**Consultation Response from KC,
Trees**

2025/91219 Land Off, Coal Pit Lane, Lower Cumberworth, Huddersfield, HD8 8PL

Outline application for erection of residential development (one dwelling)

Date Responded: 04/11/2025

DRAWING TITLE
PROPOSED SITE PLAN

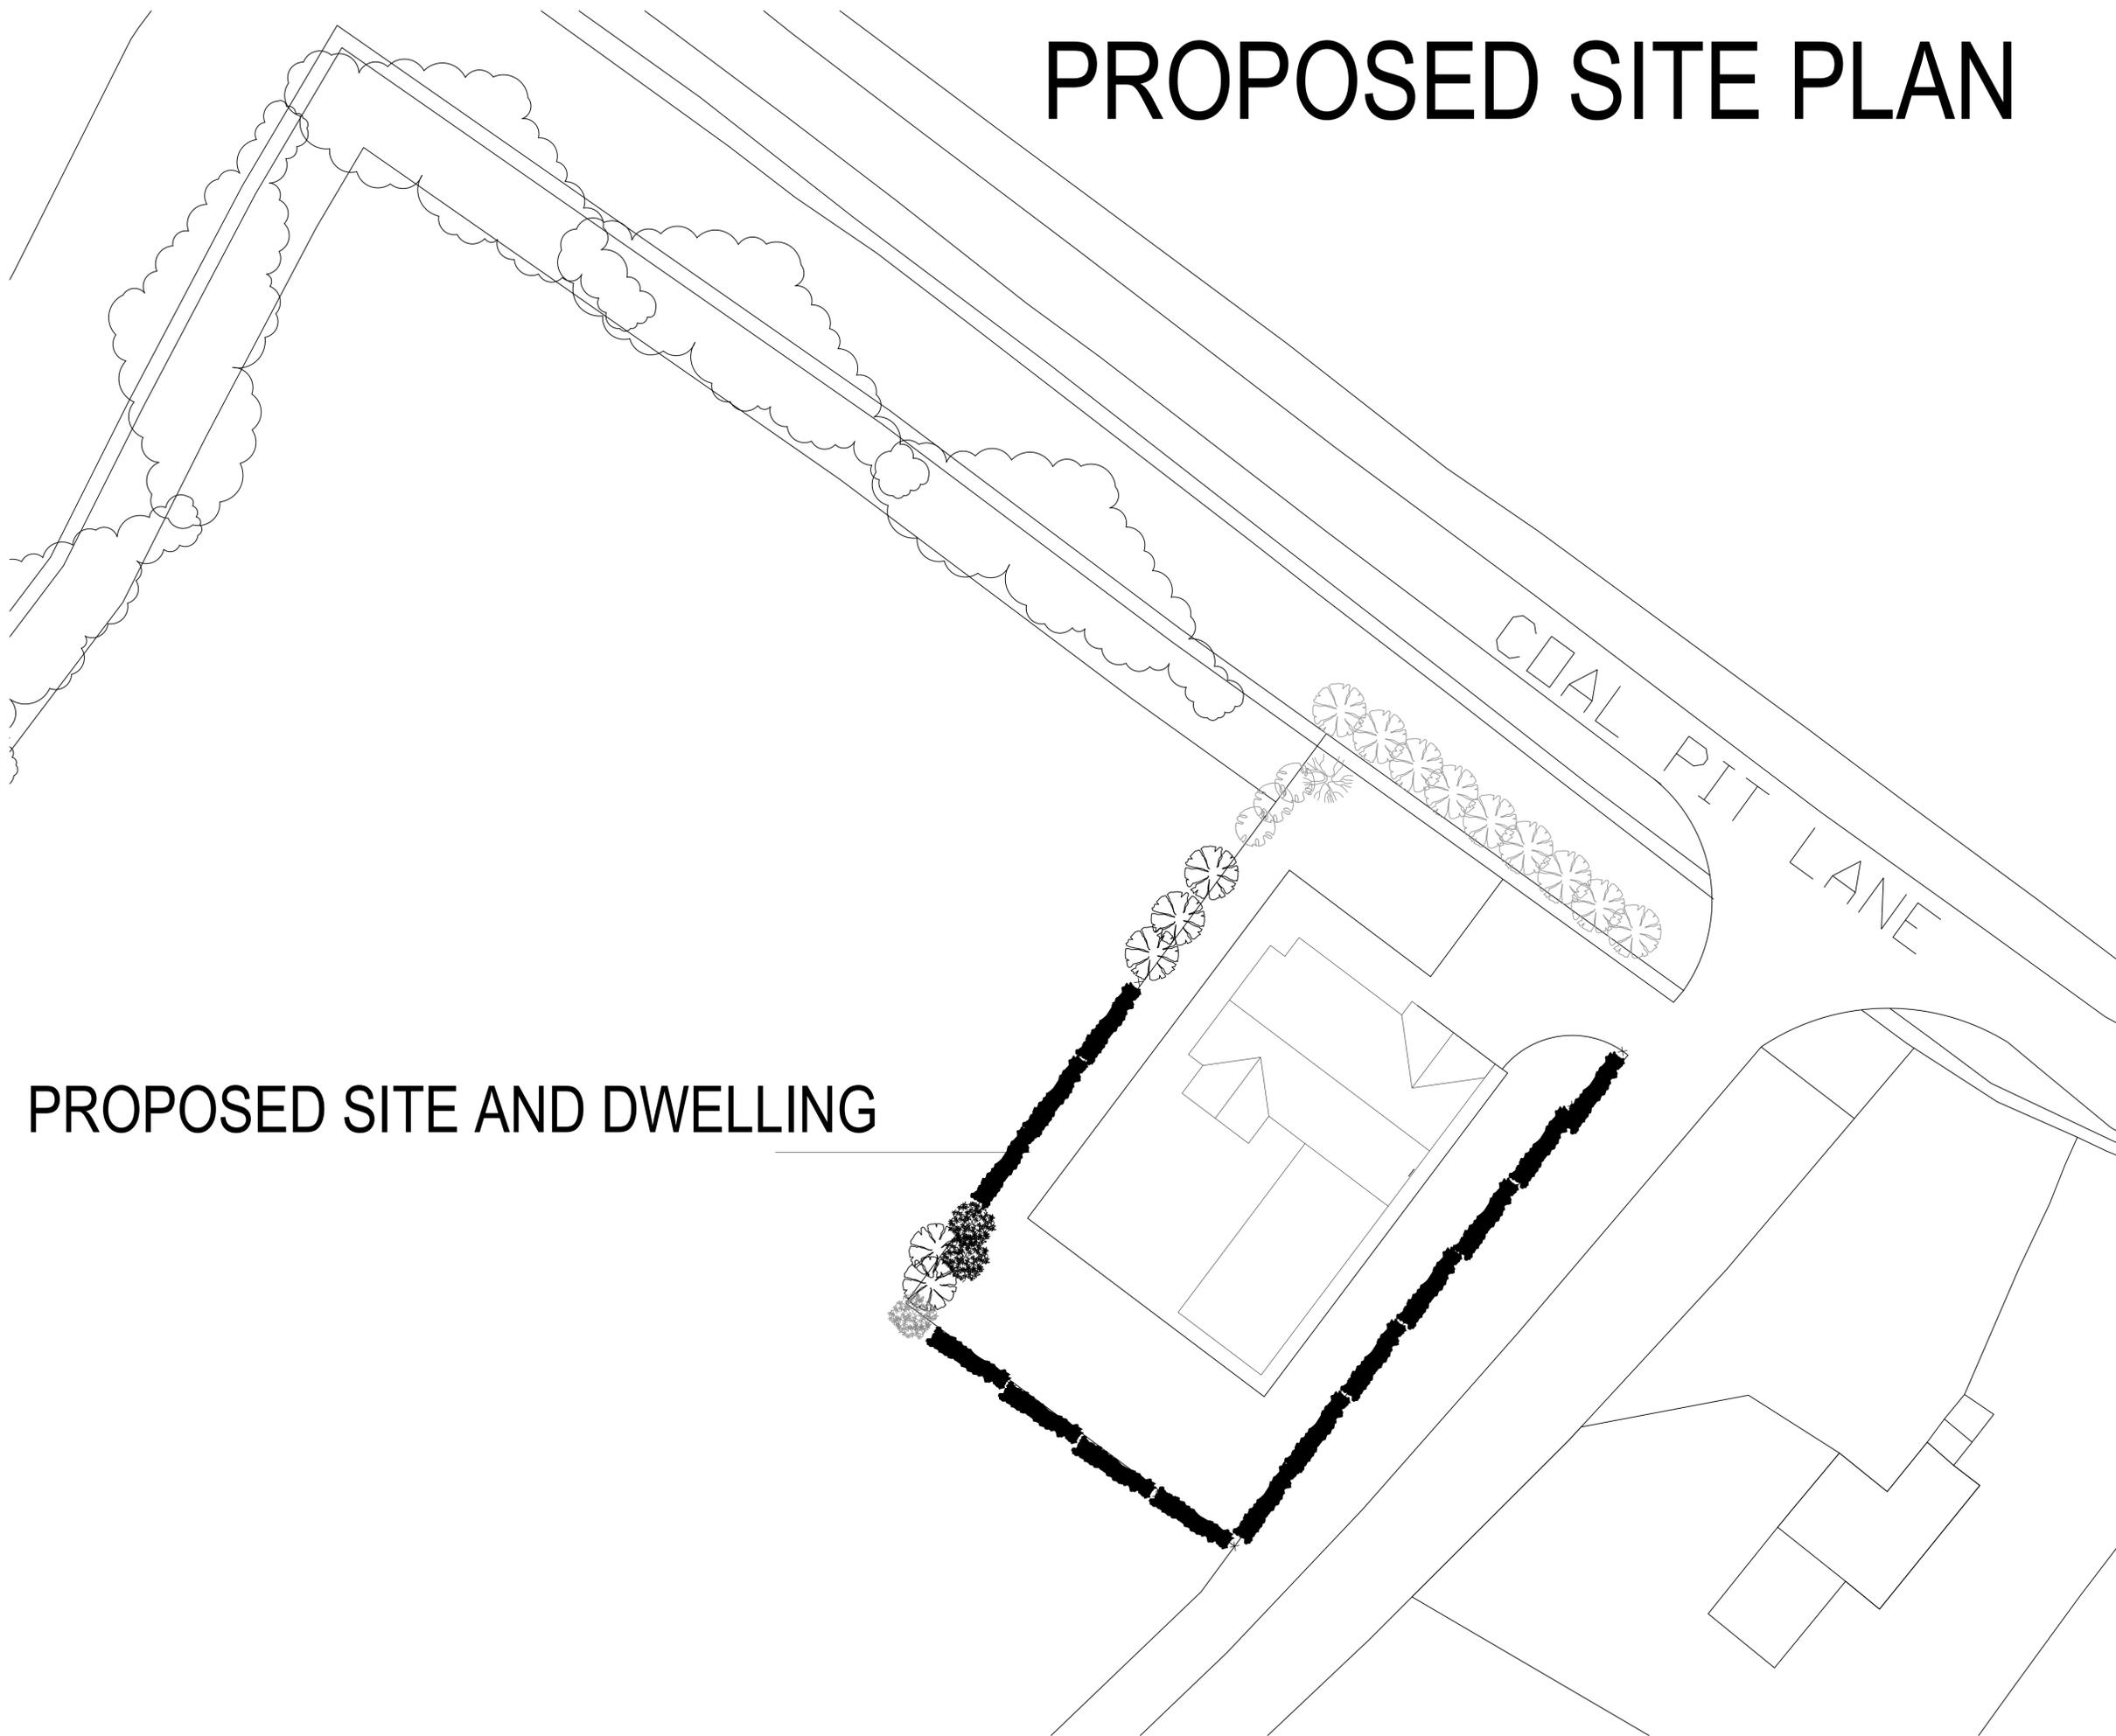
There are trees on the frontage of the site, providing screening from Coal Pit Lane. No tree information has been submitted with the application; however, tree removals would be necessary to complete the development.

There are no objections from an arboricultural perspective subject to the submission of a tree survey and AIA. Tree planting should be specified within the landscaping scheme to ensure that any tree removals which are required to complete the development are adequately compensated.
